1 to 7 Picture House Apartments, George Street, Whalley, BB7 9TH

Planning Application Reference 3/2024/1016

Position Statement

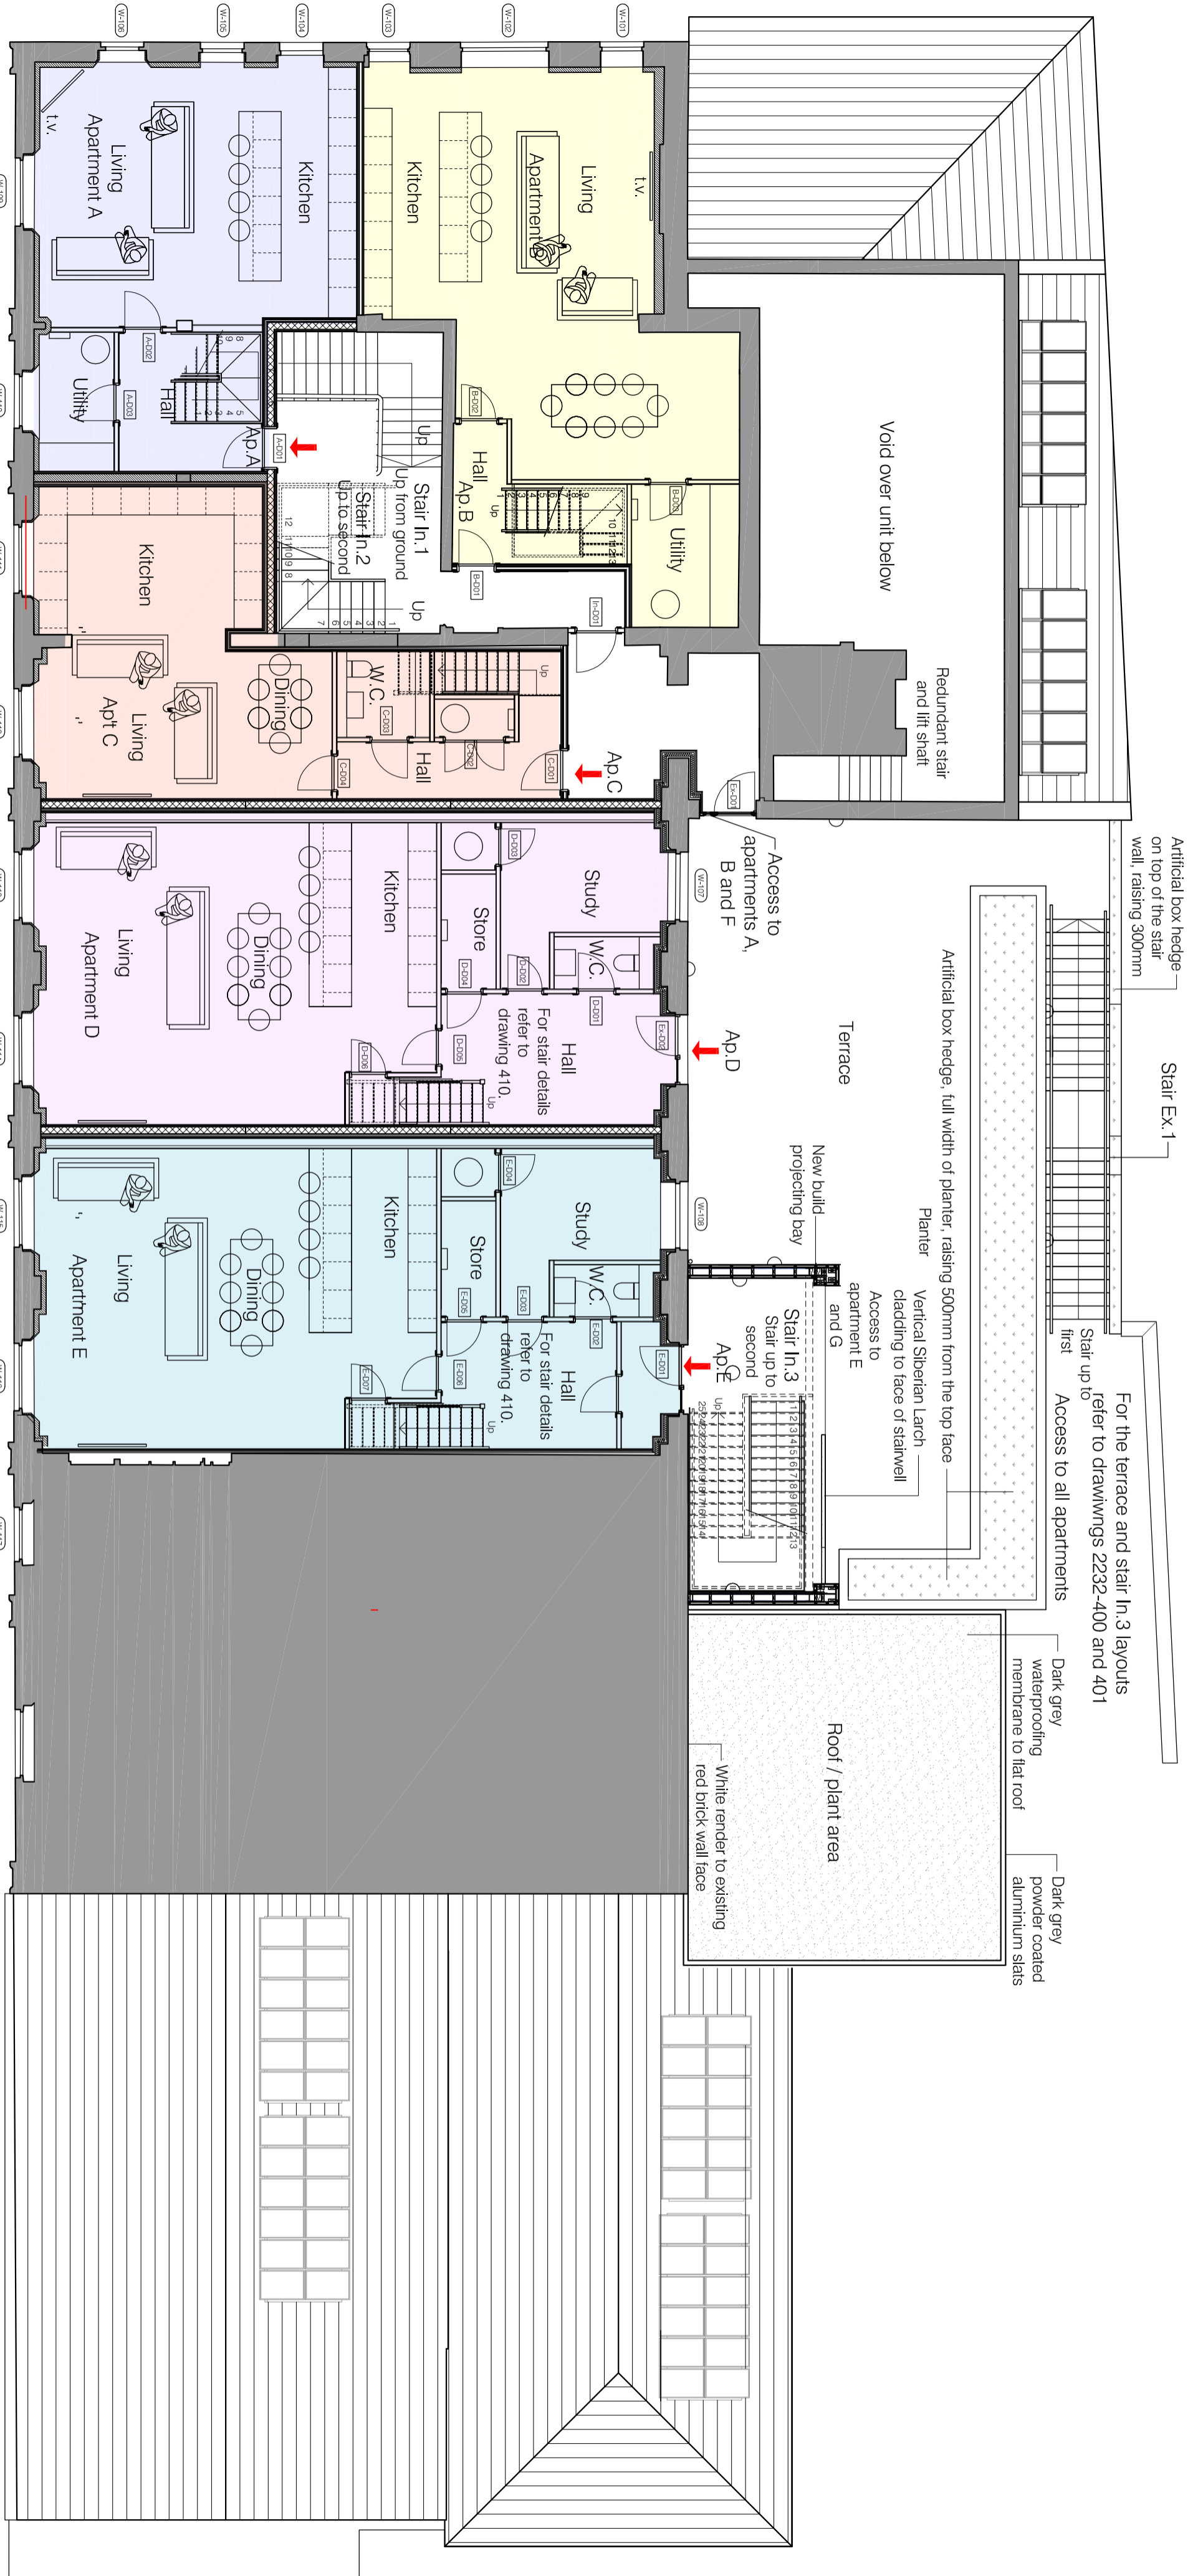
Matter	Applicant's Response	Comments
1.	Screening to Rear Terrace.	A synthetic hedge to be erected around the balcony edge and from ground level. For illustrative purposes visuals are provided: x 2 - Balcony and from Ground Level Drawing Numbers: 2232-1M-001 2232-101 AB1; 102 AB1; 103AB1; 301 AB1. Supersedes 101; 102; 103 & 301	Synthetic planting is to be erected around the balcony edge attached to the substantial screening feature (planter box) already in place. We have extended this planting up the stairs from ground floor to the balcony which will add verticality and break up the extent of render. This planting is widely used and provides effective screening all year round and is low maintenance. No material weight increase to structural roof. This approach removes any potential for overlooking of properties to the rear from the balcony.

2.	Rear Open Staircase.	Vertical larch-wood cladding, as per original consent to prevent overlooking. For illustrative purposes visuals are provided: x 2 - Balcony and from Ground Level.	The officers' suggestions have been considered by the design team and the engineers. A fully enclosed stairway is not achievable due to fire safety issues. Unrestricted access

<p>Revised drawings: 2232-101AB1; 2232-102AB1; 2232-103AB1; 2232-301AB1. Supersedes: 2232-101; 102; ; 103 & 301</p>	<p>required to the installed fire hydrant. Therefore, the decision was made to move back to the original design. Critically, this approach secures the screening required to protect residential amenity officers raised as a key issue.</p>

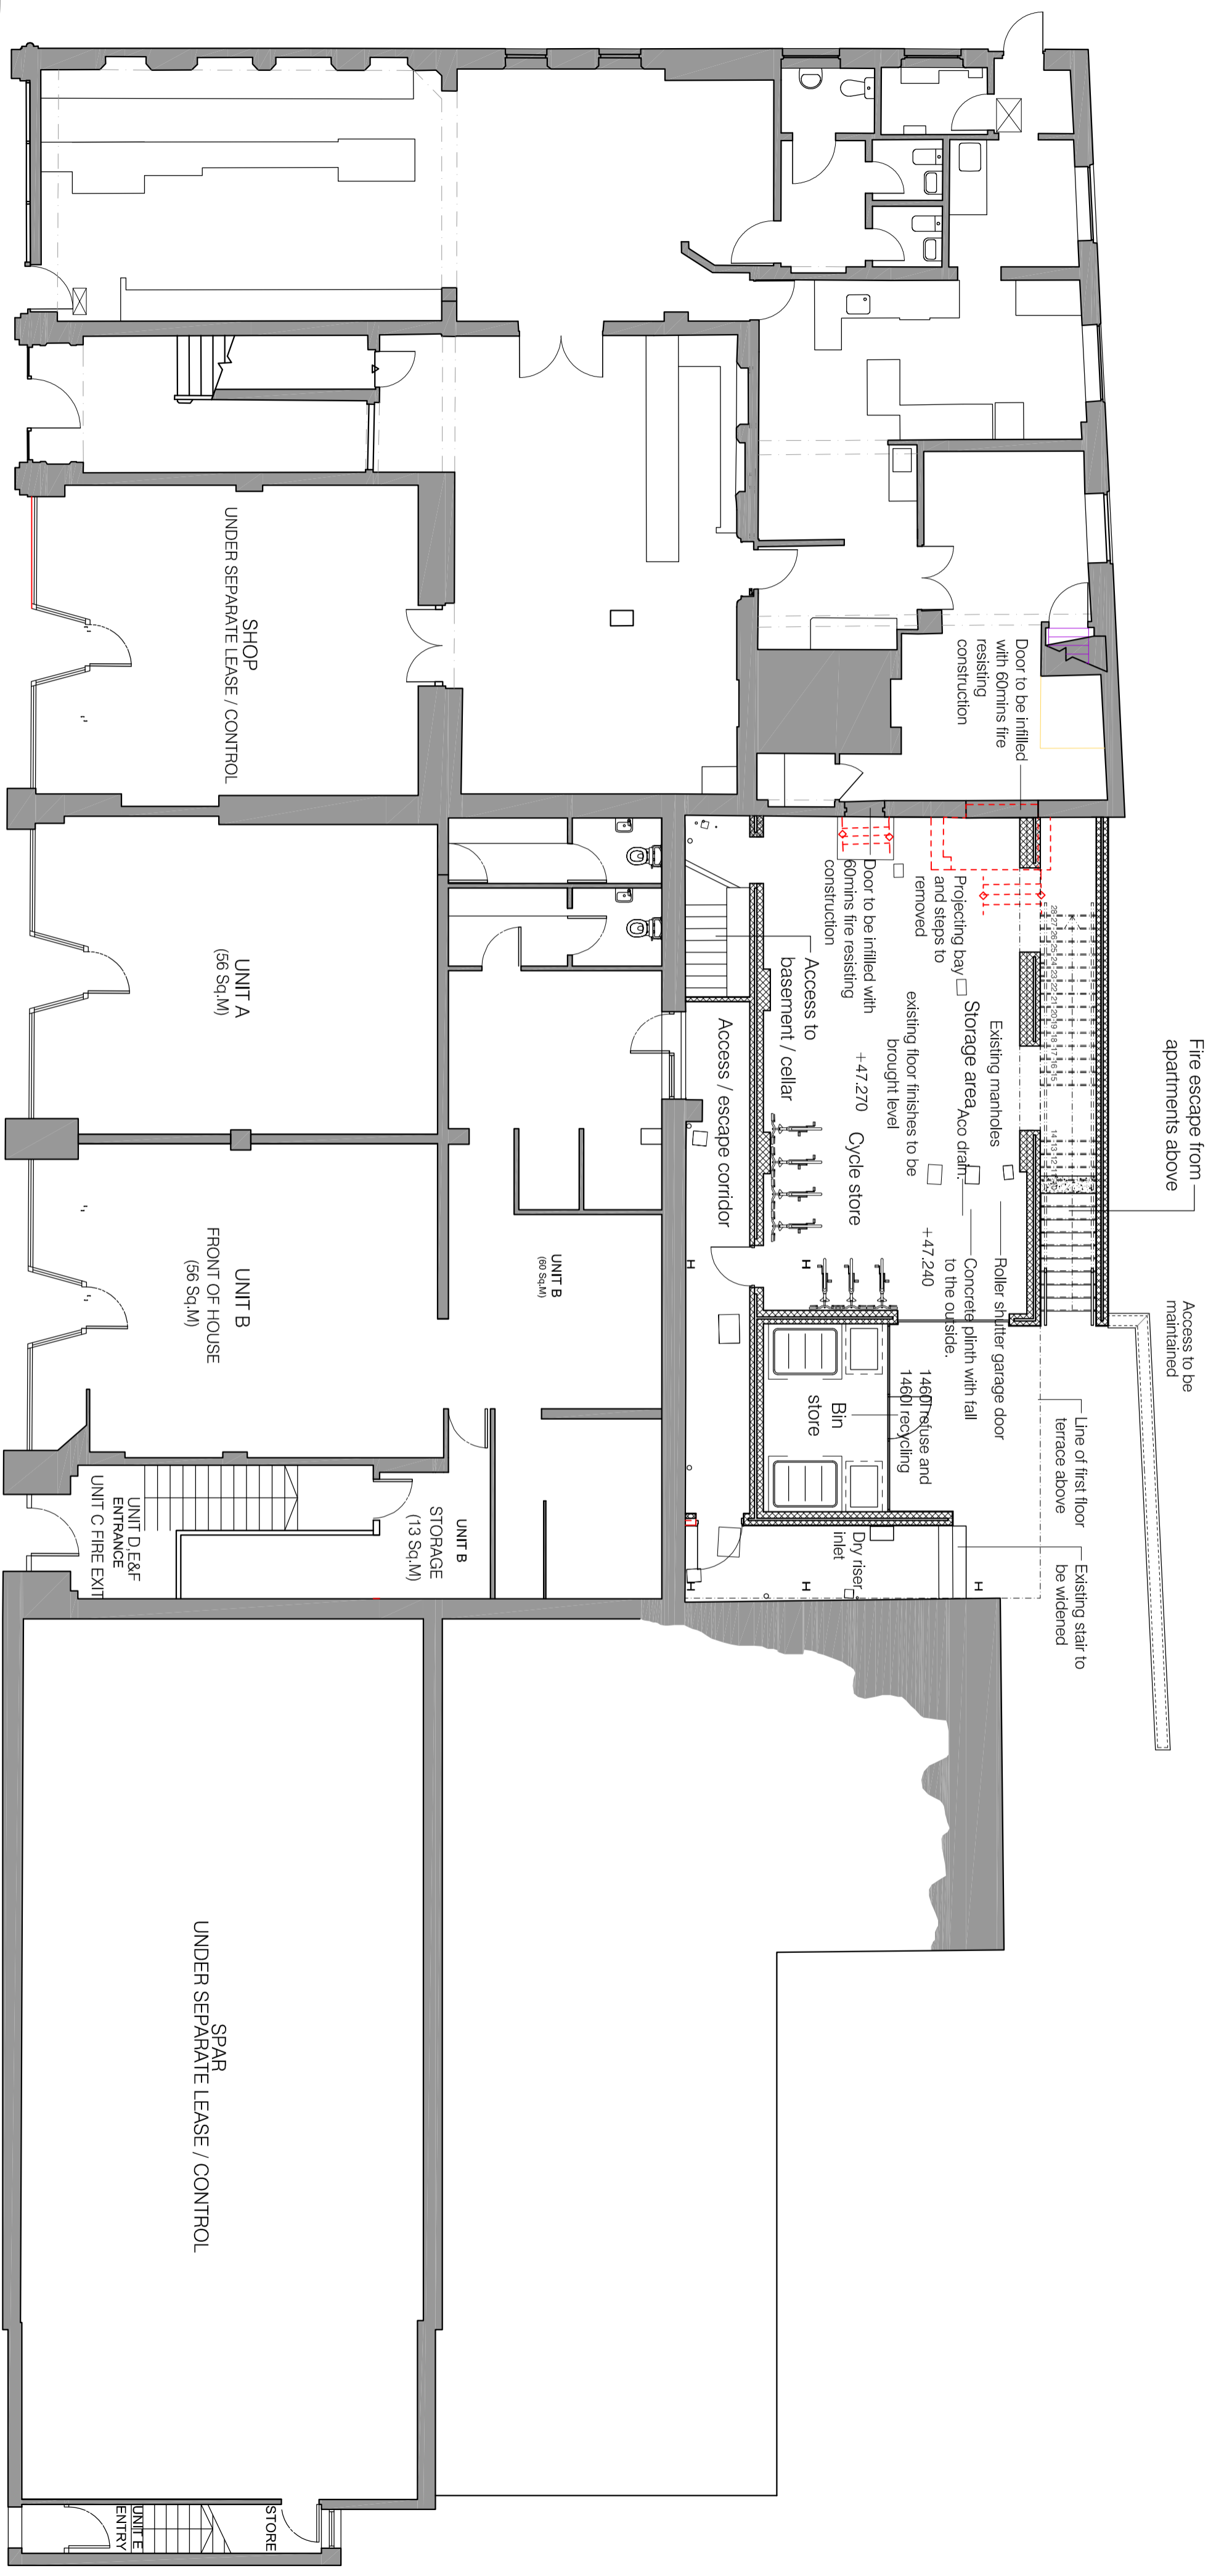
6.	Other Matters.	<ul style="list-style-type: none"> • Cycle Store repositioned. • Bin Store retained. • Roller Shutter Door retained. • EV Charging Points x 2. Revised Drawing: 2232-100 AB1. Retained rear boundary wall on original foundation. Revised Drawings: 2232-410cC; 2232-100 AB1. Superseded Drawings 2232-410 & 100	This will be retained inside the building as submitted to improve security and ease of access. Bin Store: RVBC confirmed no further information is required. Roller Shutter: RVBC confirmed no further information is required. EVCP: Expert/qualified advice received on limited grid-load capability. There is no development plan requirement for 1 EV Charging Point per dwelling. Rear wall: Wrongly described as re-positioned. New wall has been built on original foundations. More secure with better access.
